Reference No: 2021/62/91262/W

Site Address: 15, Deer Croft Road, Salendine Nook, Huddersfield,
HD3 3SN

Description: Erection of two storey side and single storey rear
extensions

Officer Report

FRONT ELEVATION:

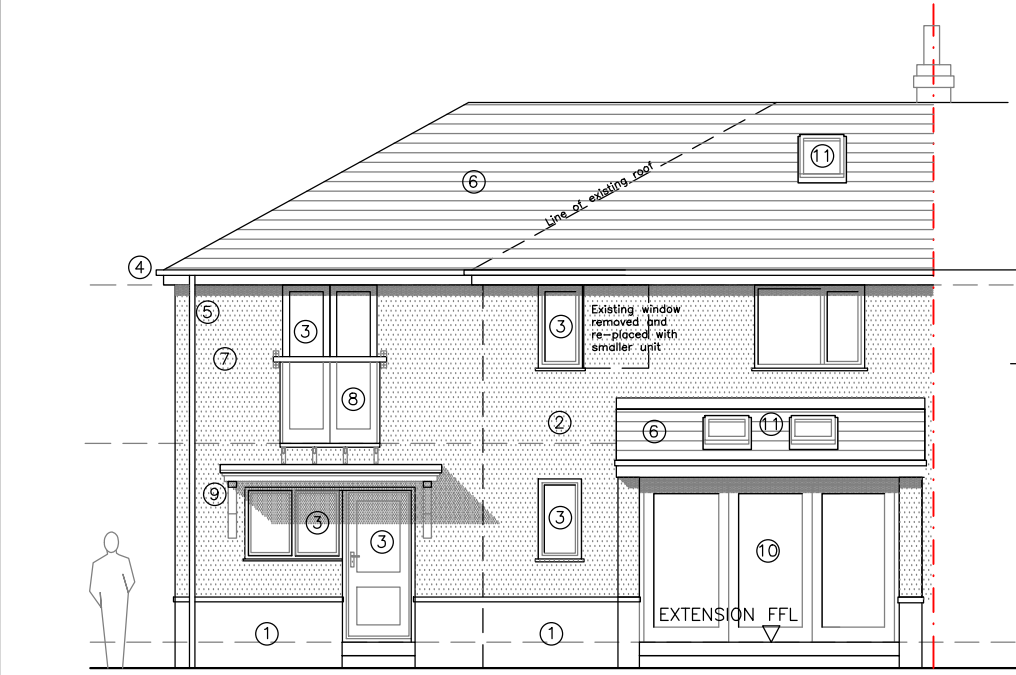
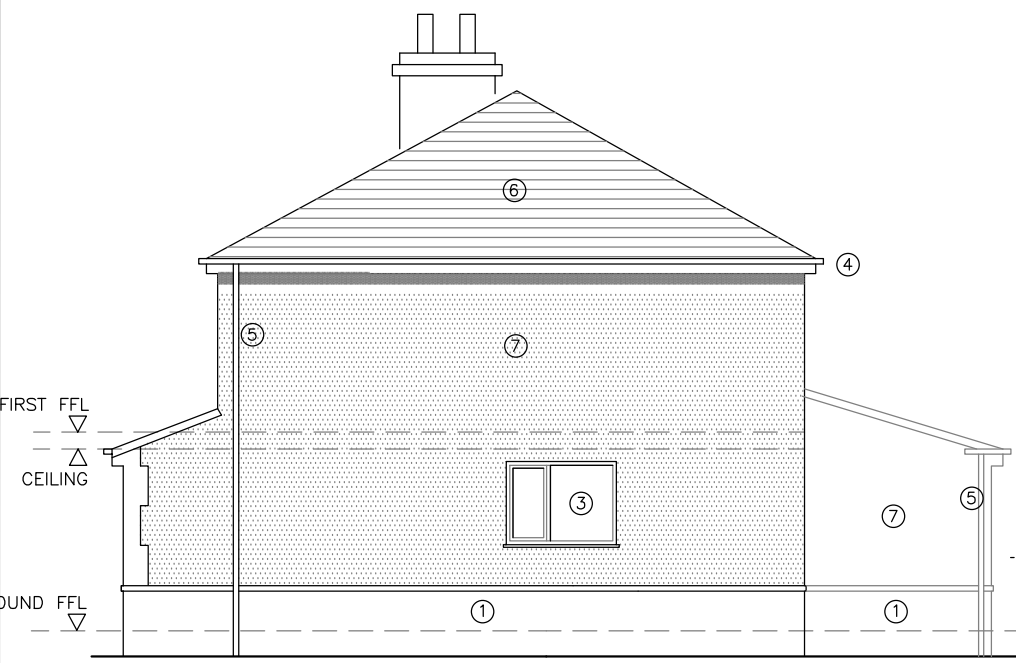
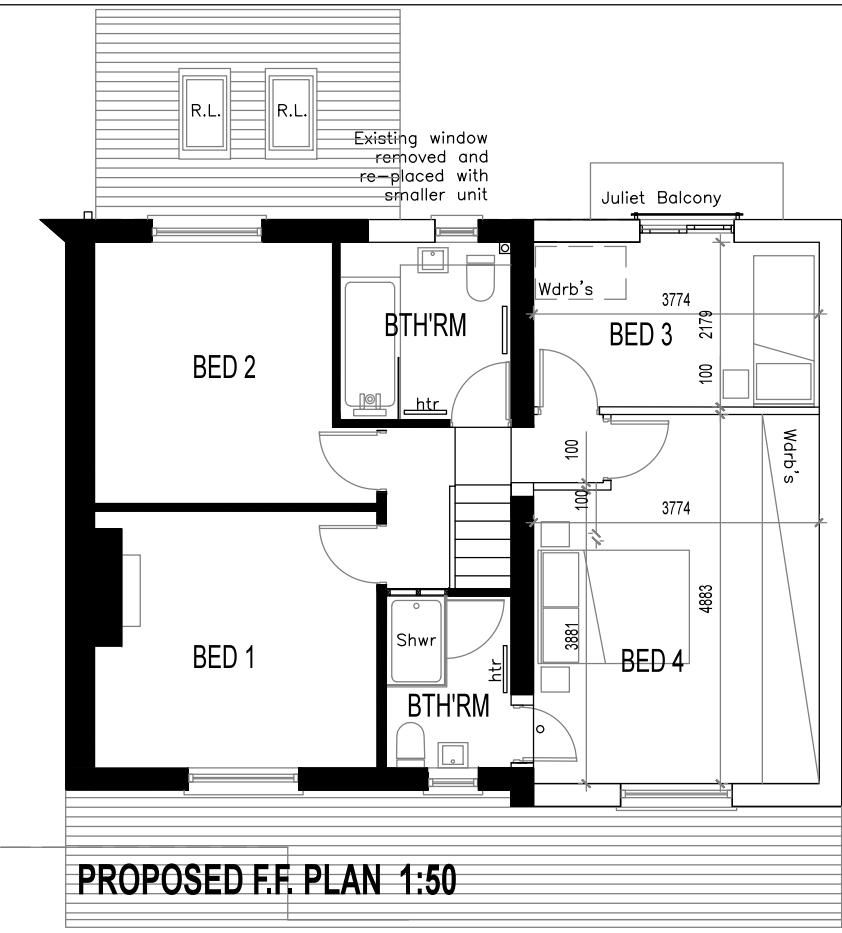
The Agent was contacted with a view to seeking amended plans to set the extension back from the front elevation of property as it was considered a better to be designed to maintain symmetry to the neighbour and also because of the prominence of the location. The Agent has responded in detail explaining the requirements of the applicant and therefore no amended plans were submitted and the assessment is made on the original submission, for the considerations outlined below it is considered that the proposals are acceptable on balance.

The proposed extensions would be located on the front, side and rear elevations and would result in the demolition of the existing garage to facilitate the development. The two storey side extension would have an eaves height and roof ridge height to match the host property which would be in keeping.

The attached neighbouring property has also been extended with a porch to the front and side extension, however this is set back from the existing front elevation. Due to the orientation the property with the adjacent property, 43 Moor Hill Road, which is a bungalow, it is not considered that a terracing effect would occur with this property. It is proposed that the existing property would be re-rendered and the proposed extension would be rendered to match. The single storey rear extension would also be constructed from matching materials and would appear as a subservient structure due to being single storey in height. In addition, a canopy would be formed at the ground floor level of the front elevation which would span the full width of the front elevation and extension which is also considered not to be visually intrusive. Whilst officers engaged with the agent to consider revising the design to match the neighbour not details were submitted. Whilst it would be preferable to maintain symmetry the proposals are considered, on balance, to meet Policy.

PROPOSED G.F. PLAN
1:50

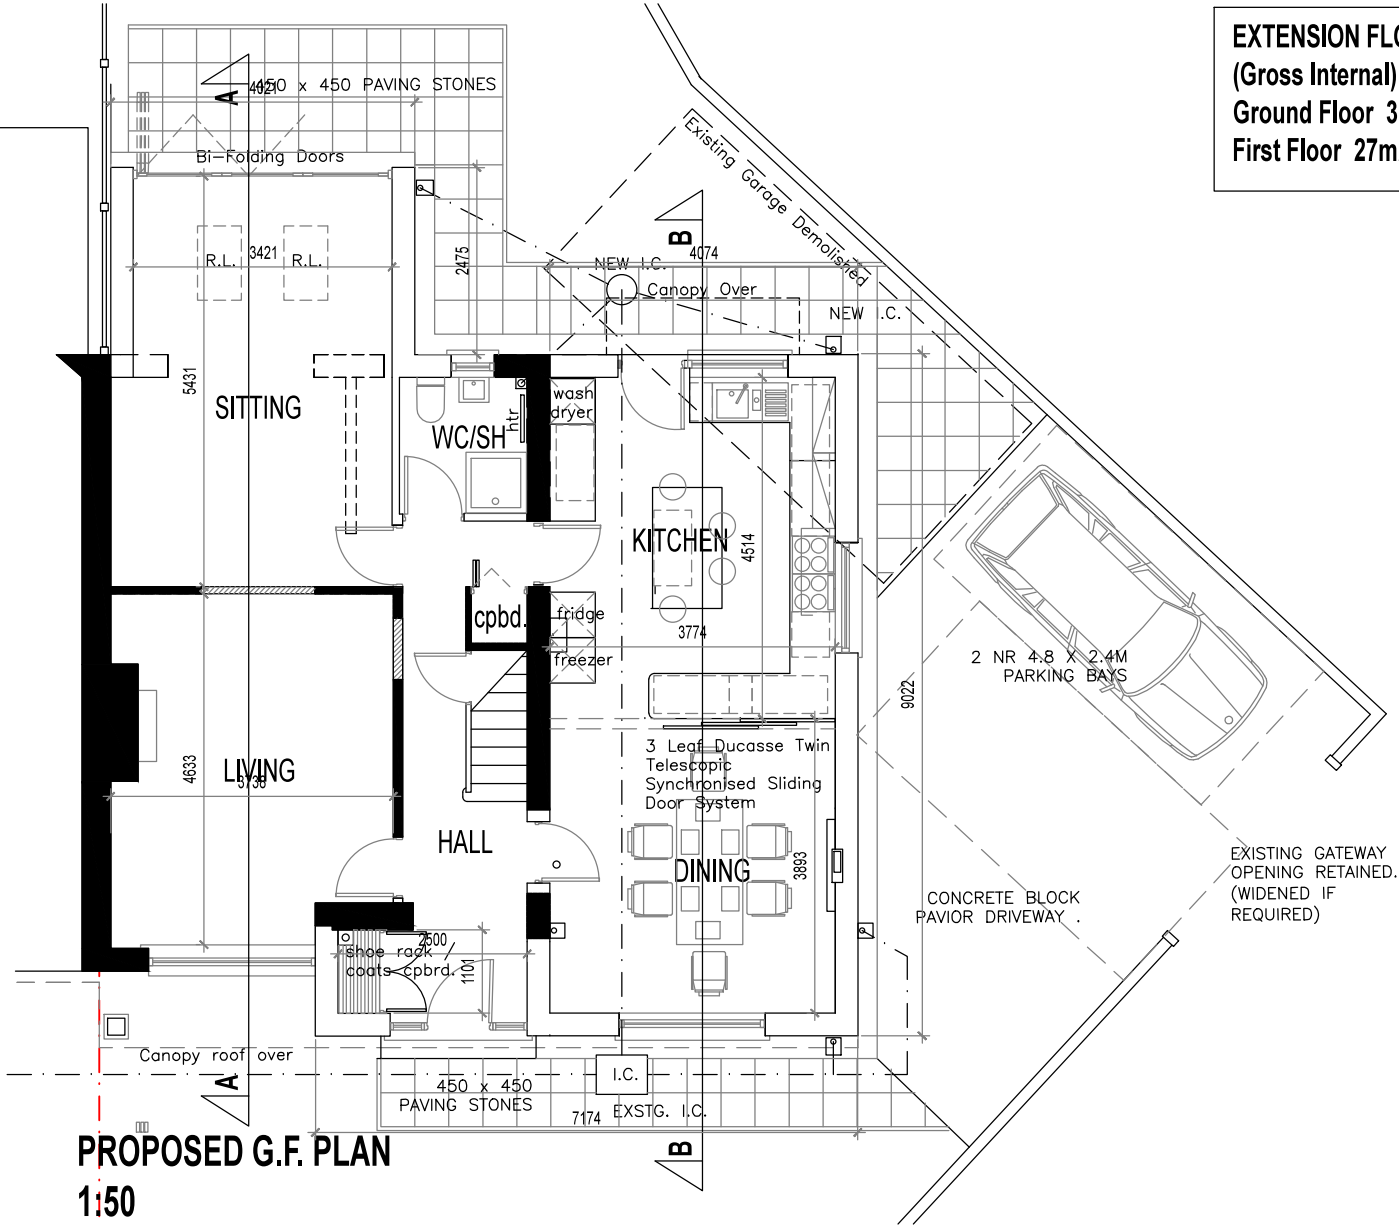
The existing garage would be demolished to accommodate the extension. The proposed ground floor plan demonstrates 2 no. off-street parking spaces. As stated within the Highways Design Guide SPD as the property would be a 4 bedroom dwelling, 3 no. parking spaces should be provided. Whilst these can't be accommodated within the site, on-street parking is available and is unrestricted. It does not appear that on-street parking is oversubscribed within the immediate area. As such, the proposals are acceptable on balance.
